Phone: 0300 123 6780
Email: developeras@lancashire.gov.uk
Your ref: 3/2025/0733
Our ref: 3/2025/0733/HDC/LB
Date: 18/05/2026

Location: 41 St Marys Drive Langho BB6 8DL
Proposal: Proposed side extension with front and rear dormer roof extensions
Grid Ref: 370573 433997

PROPOSED SITE PLAN
(SCALE 1:500)

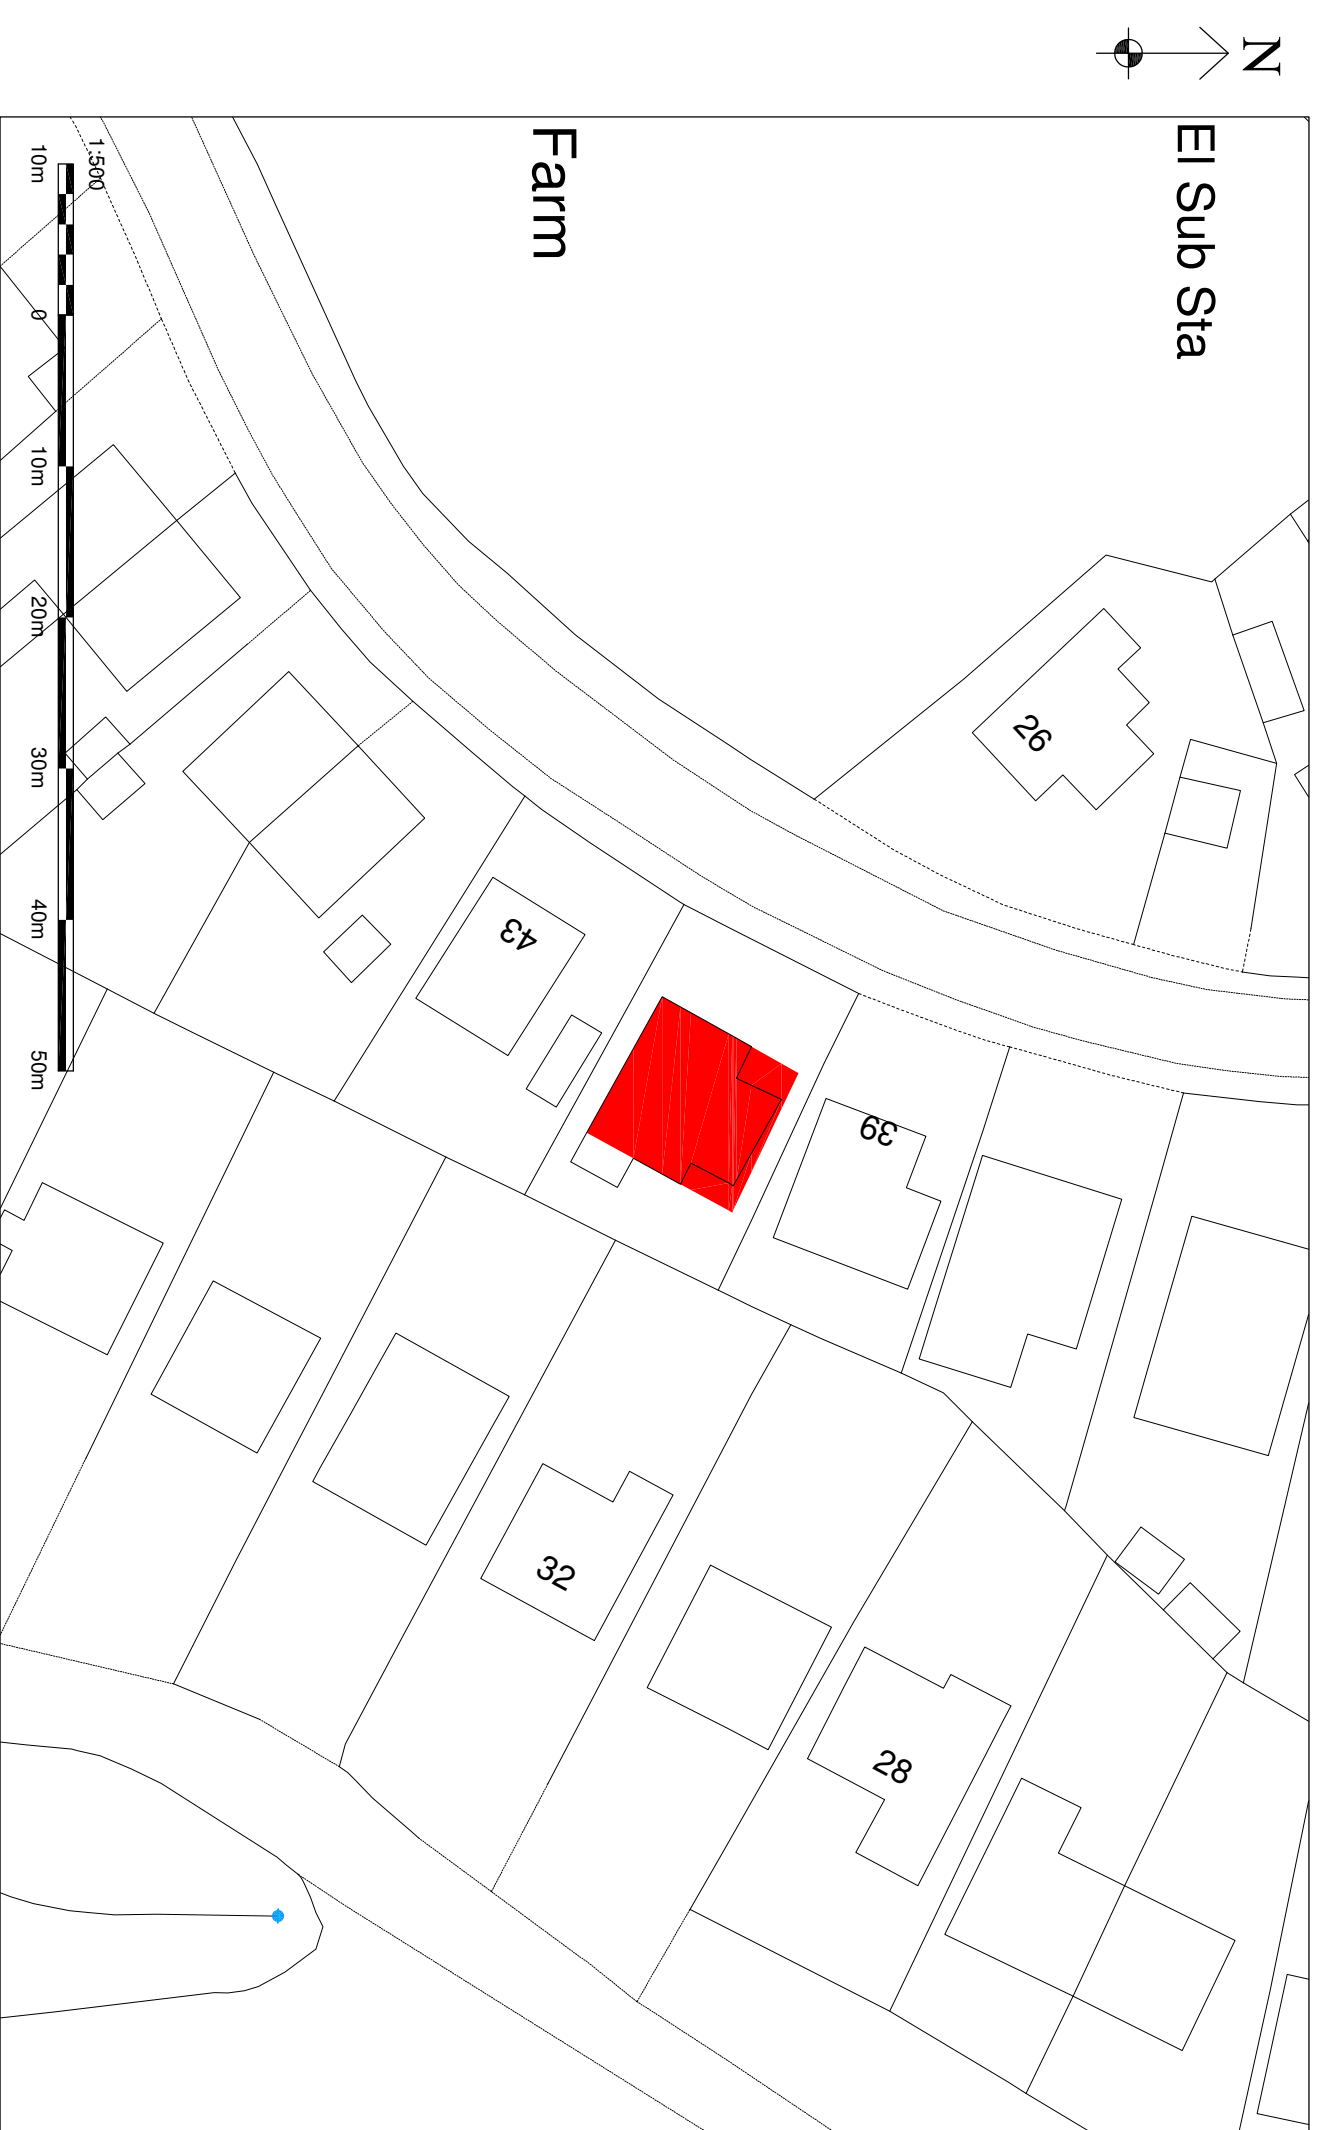
The submitted documents have been reviewed, as shown in drawing 'Amended Site Plan No.101', the proposed off street parking spaces vary in length, with bay three being the shortest. To safely accommodate off street parking and in the interest of highway safety, we request that the parking spaces each measure 5m in length and 2.4m in width.

Lancashire County Council Highways request that the applicant provides amended plans showing how the off-street parking is to be achieved considering the above information and in accordance with the recommended standards prior to the application being determined.
